Recommendation Report for Planning Permission for Works or Extension to a Dwelling

REF NO: BE/34/19/HH

LOCATION: 54 Mansfield Road
Bognor Regis
PO22 9HB

PROPOSAL: Rear single storey extension.

SCALE - 1/50 REV - B DATE - 04/03/2019

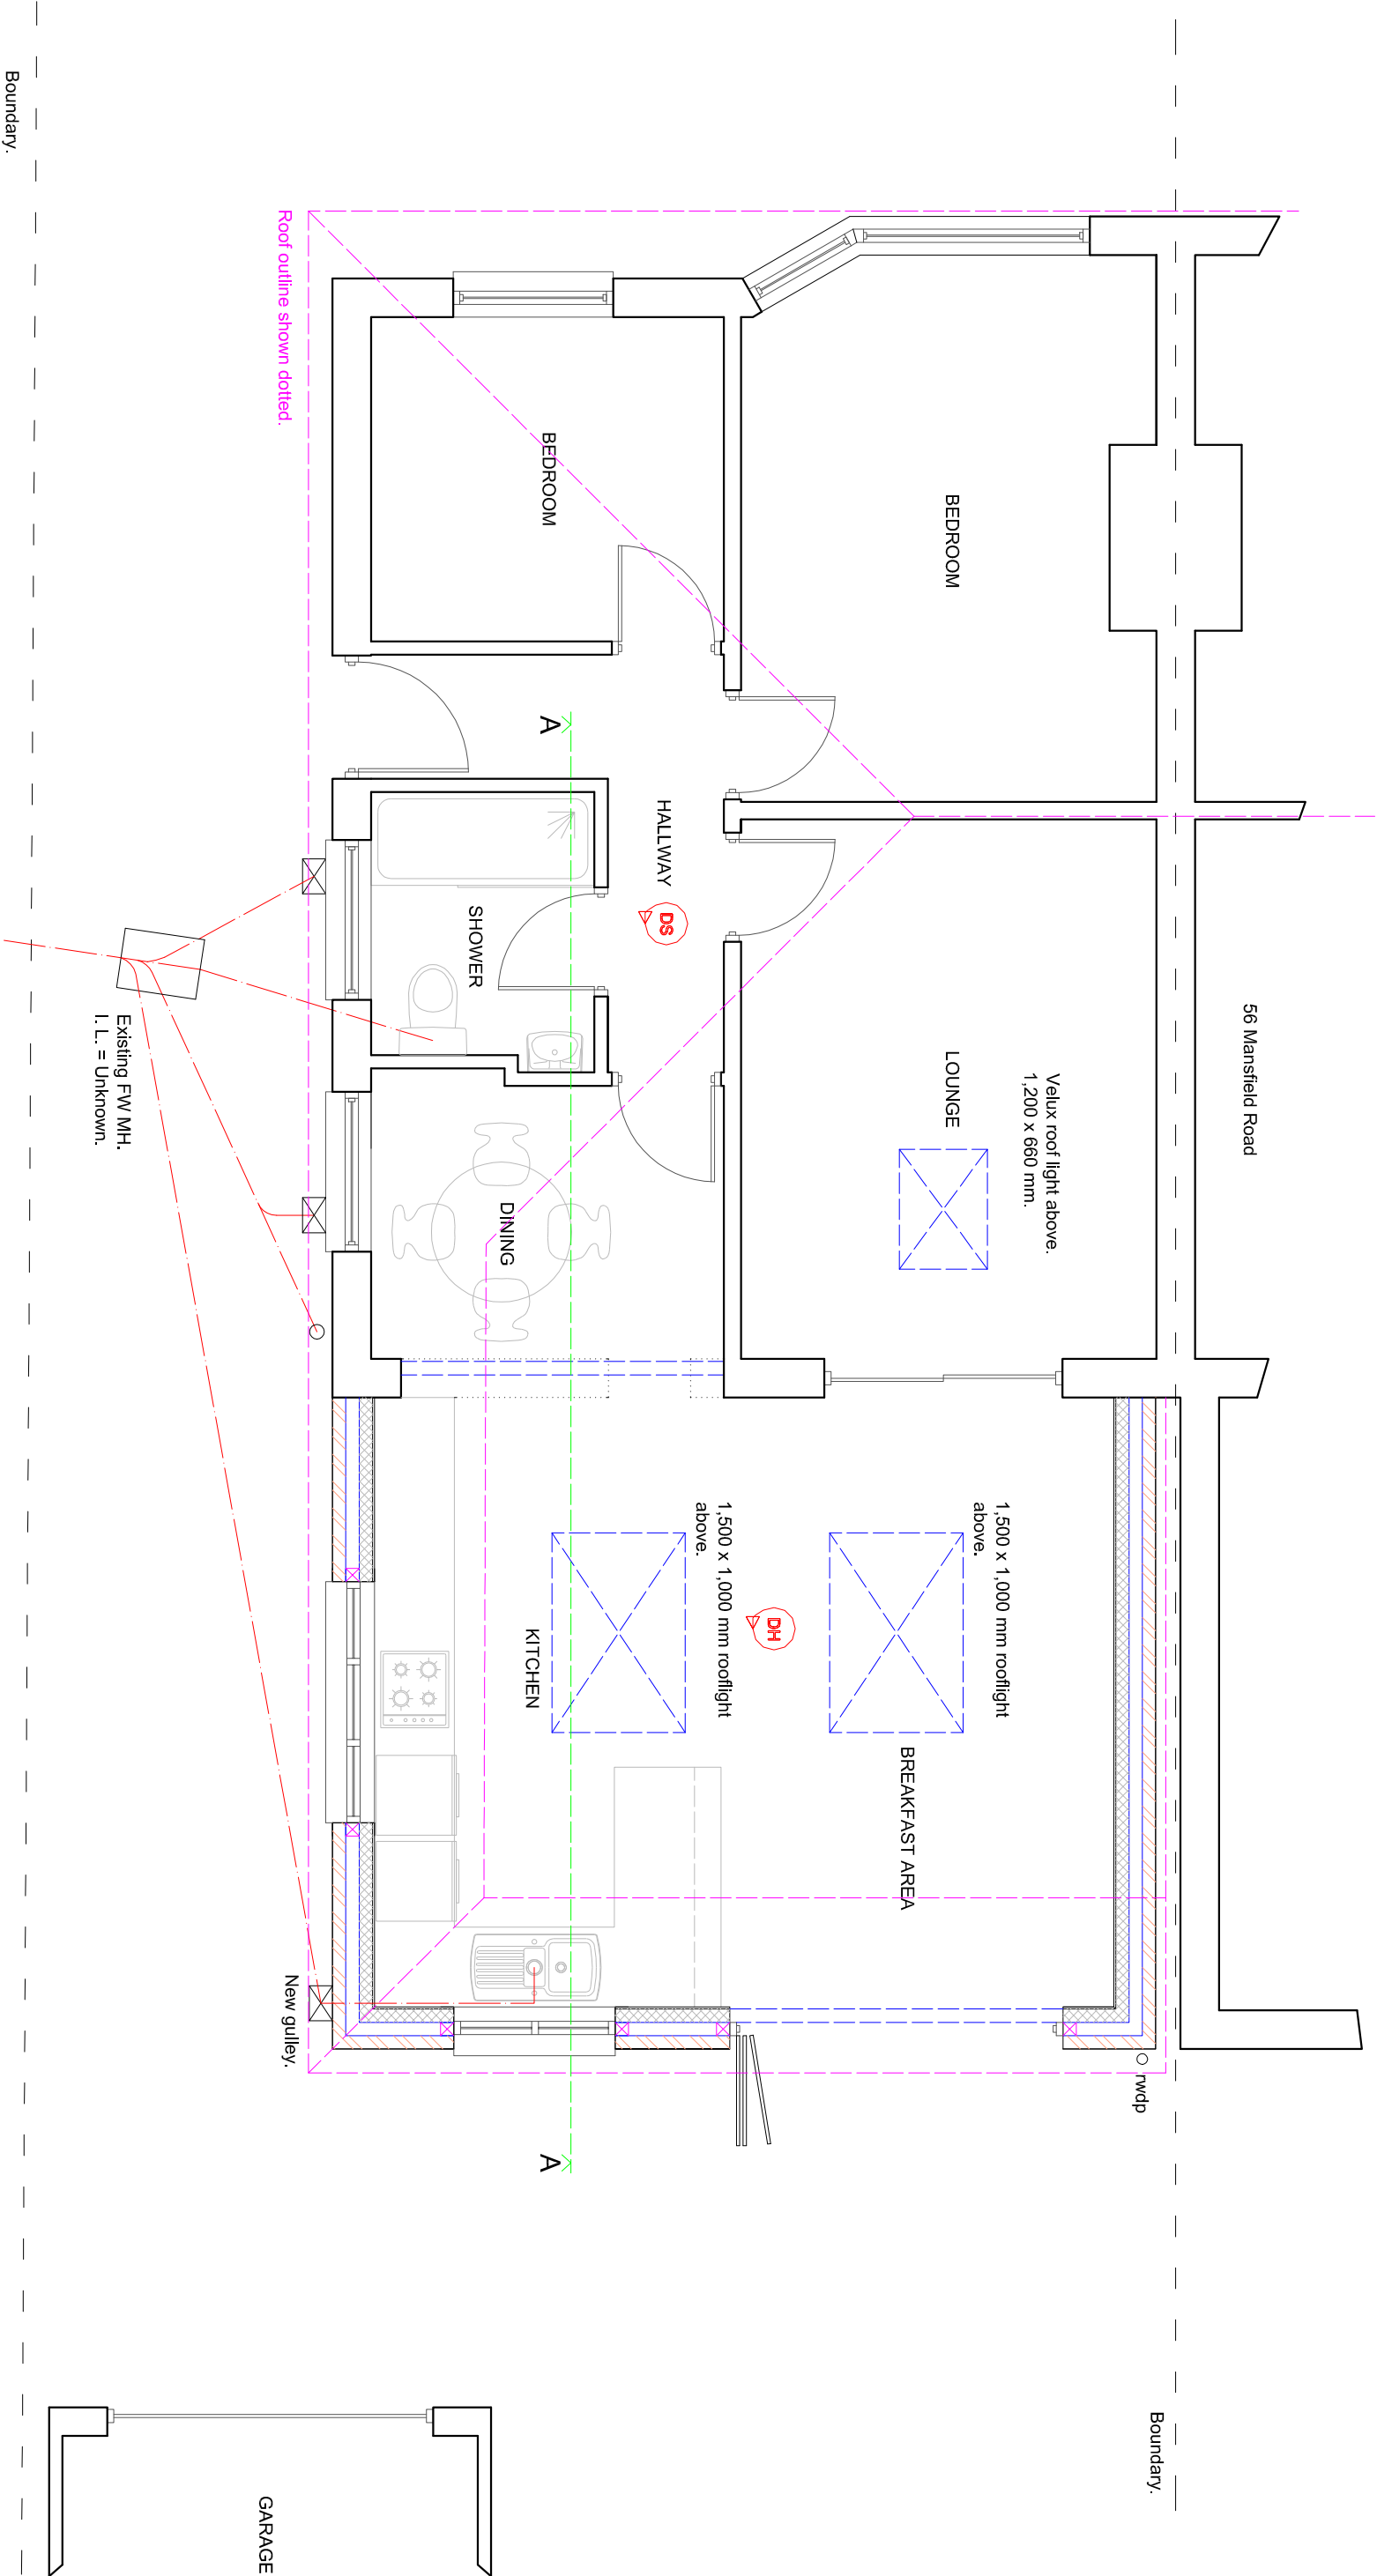
The proposed rear extension will be located approximately 0.1m from the Northern boundary, 1.25m from the Southern Boundary and 27.3m from the Eastern boundary. The proposed extension will feature bi-fold doors and 1No. window on the Eastern elevation. Given the distance from the bi-fold doors and window and the Eastern boundary of the site is approximately 27.3m and will overlook the rear garden at ground floor level., they will not give rise to any additional overlooking or loss of privacy to the neighbouring properties. The extension will also include 2No. roof lights, however by virtue of the design of the proposed extension and the location of these windows they will not result in any unacceptably adverse overlooking of neighbouring properties. No windows or doors have been incorporated on the Northern or Southern elevations to further mitigate any potential impact upon neighbouring properties.

PROPOSED ELEVATIONS

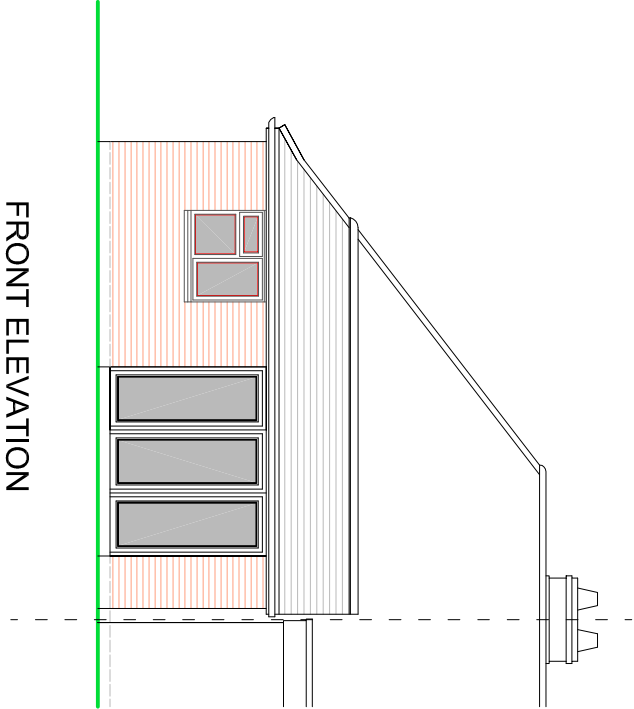
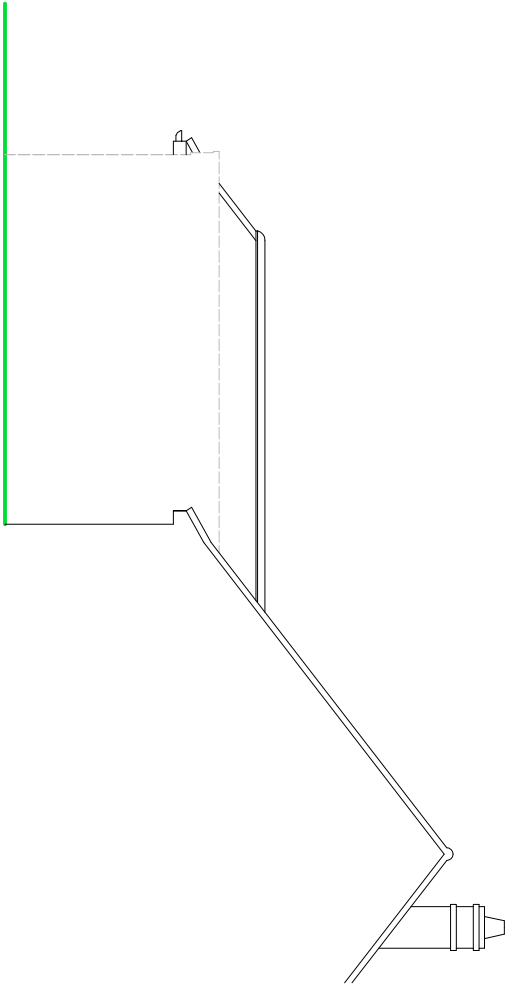
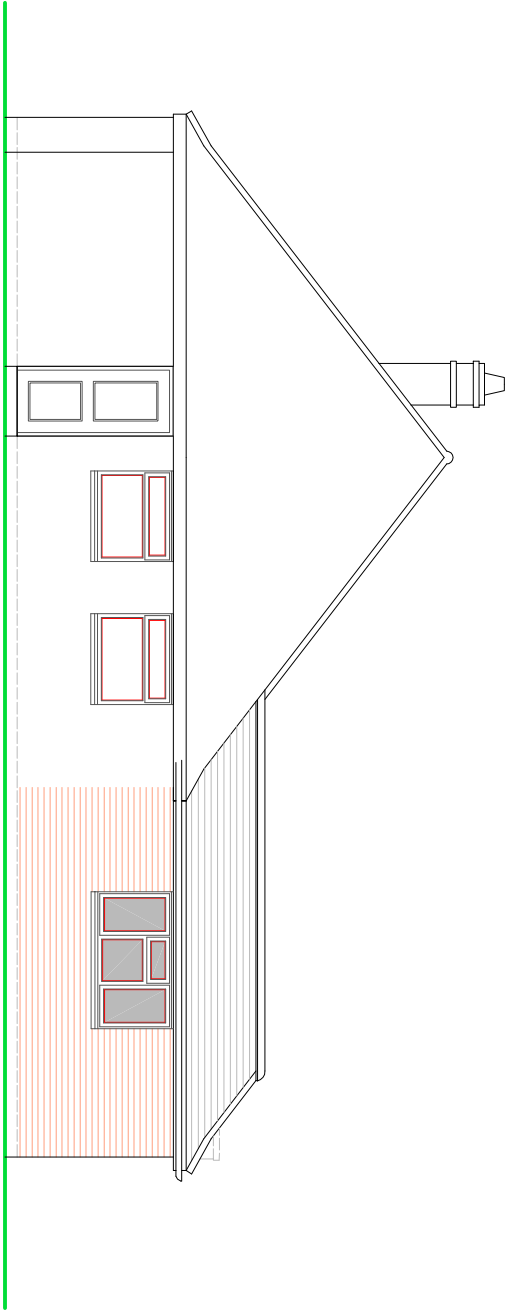
The proposed rear extension will measure approximately 4.9m in length, 6.3m in width and be built to a height of 2.9m. The proposal will not have a detrimental impact on the character of the host dwelling or the street scene.

The proposed extension will be constructed from materials which will match the existing dwelling which further assist with the integration of the extension with the host dwelling.
